ABP Oral Hearing – Module 2 Tuesday 12th March

TII's response to relocating the Collins Avenue Station to Albert College Park

Slide 1 – Alternative Station Location at Albert College Park

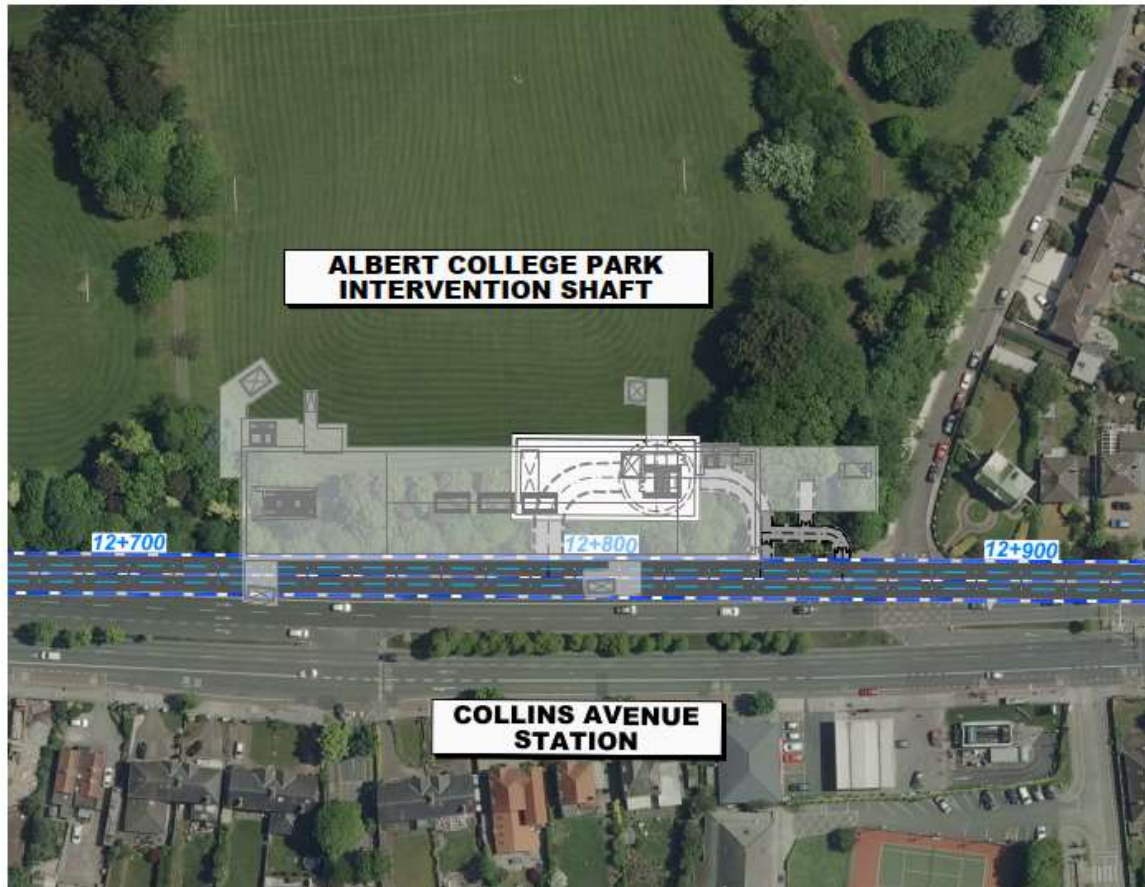
Slide 1 – Alternative Station Location at Albert College Park

Note:
Proposed Collins Avenue station
outline superimposed on ACP
Intervention Shaft location for
illustrative purposes only.

- Collins Avenue had the second-highest number of objections after Griffith Park (Na Fianna).
- Collins Avenue objections nearly equal all other objections combined!
- Albert College Residents, Ballymun Road Residents, Hampstead Residents, Griffith Avenue Residents among other groups of residents share the same opinion – The station should be relocated to the park!
- A large number of changes were made along the route – why was there no changes relating to Collins Ave?
